7 July 2017

STATE SIGNIFICANT DEVELOPMENTS – BERRIMA RAIL PROJECT (SSD7171) AND – HUME COAL PROJECT (SSD7172)

Generated project daily traffic movement  
Berrima Rail Project  
Environmental impact statement  
Figure 9.4

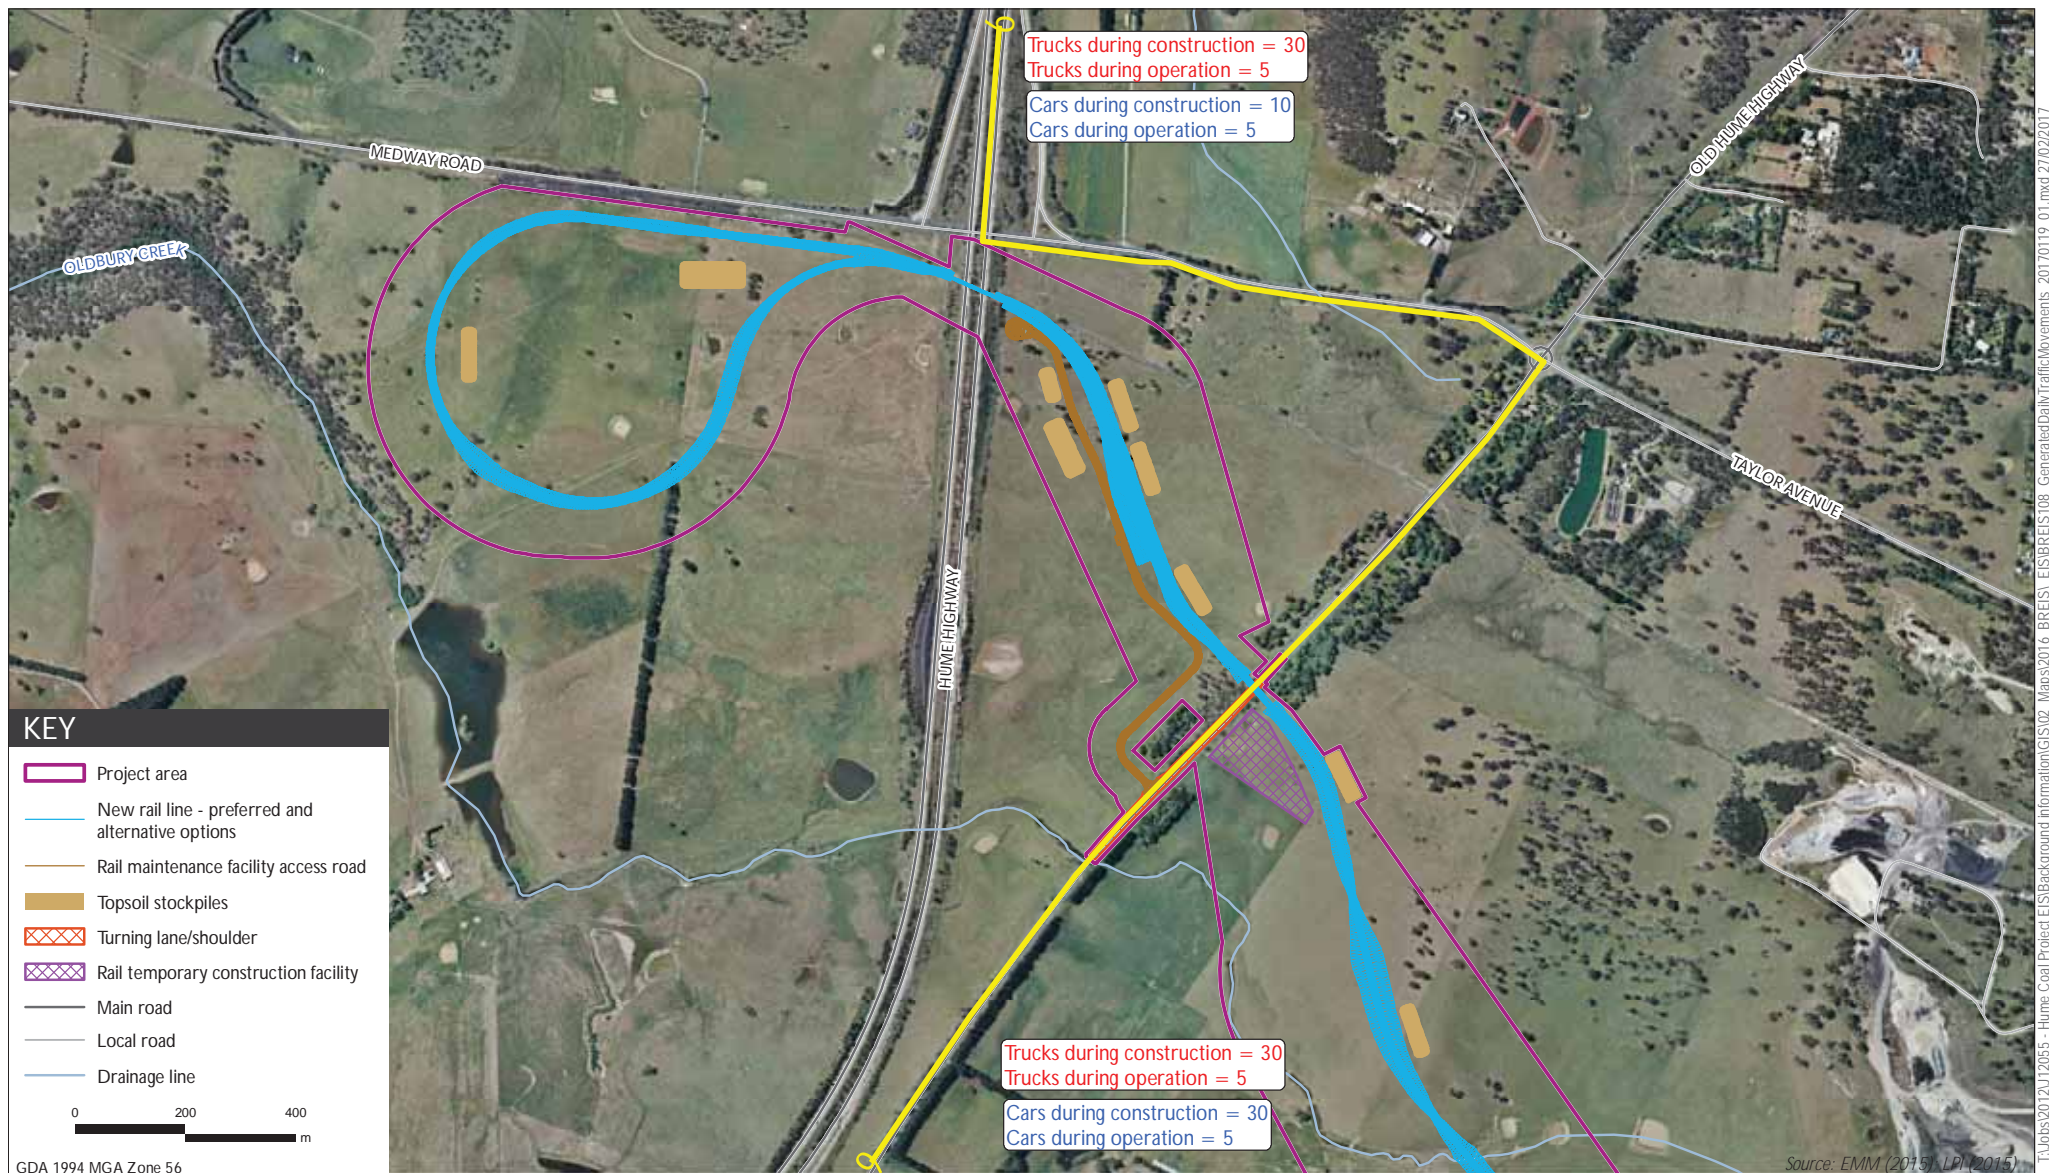
- *Traffic Movements:* RMS requires verification as to how the predicted traffic movements were derived (Table 15.8 of the EIS and Appendix M);
- *Hume Highway/Golden Vale Road intersection:* Currently, RMS has concerns with increased movements and potential increased safety risks at the Hume Highway and Golden Vale Road intersection, particularly the right turns into and out of Golden Vale Road. RMS requires further analysis of the acceleration and deceleration facilities and their suitability with the potential for increased usage as a result of the Hume Coal Project;
